5 October 2017

Roads and Maritime Reference: SYD17/00445/03 (A19144485)
DP&E Ref: SSD 8351

**STAGE 1 CONCEPT PROPOSAL FOR THE DEVELOPMENT OF THE MARTIN PLACE
STATION PRECINCT
RESPONSE TO SUBMISSIONS**

Figure 13 Indicative access to new and existing service yards

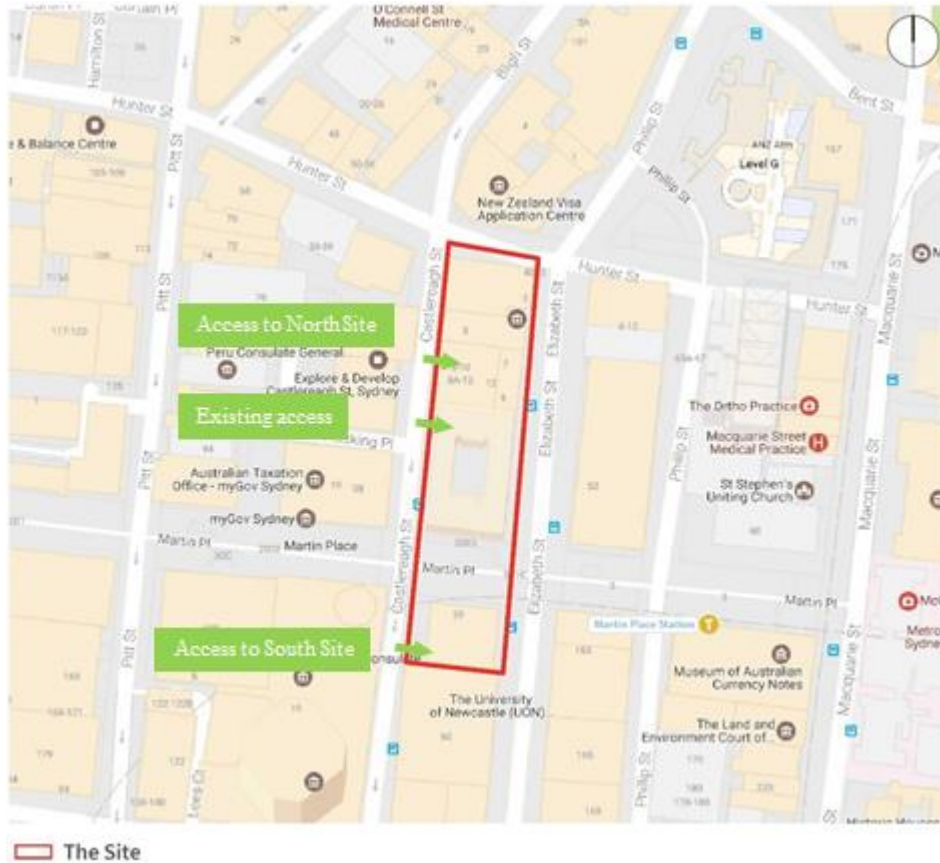
2. The layout of any proposed loading/parking areas associated with the subject development (including, driveways, grades, turn paths, sight distance requirements in relation to landscaping and/or fencing, aisle widths, aisle lengths, and parking bay dimensions) should be in accordance with AS 2890.1- 2004, AS2890.6-2009 and AS 2890.2 – 2002 for heavy vehicle usage.

3. The proposed vehicular access points for the loading dock should be located as far as reasonably practical away from the traffic control signals on Castlereagh Street.

4. The proposed loading dock capacity should be adequate to cater for the full service vehicle demands of the ultimate development. An assessment of the loading dock capacity and details of proposed management plans should accompany any Stage 2 development application.
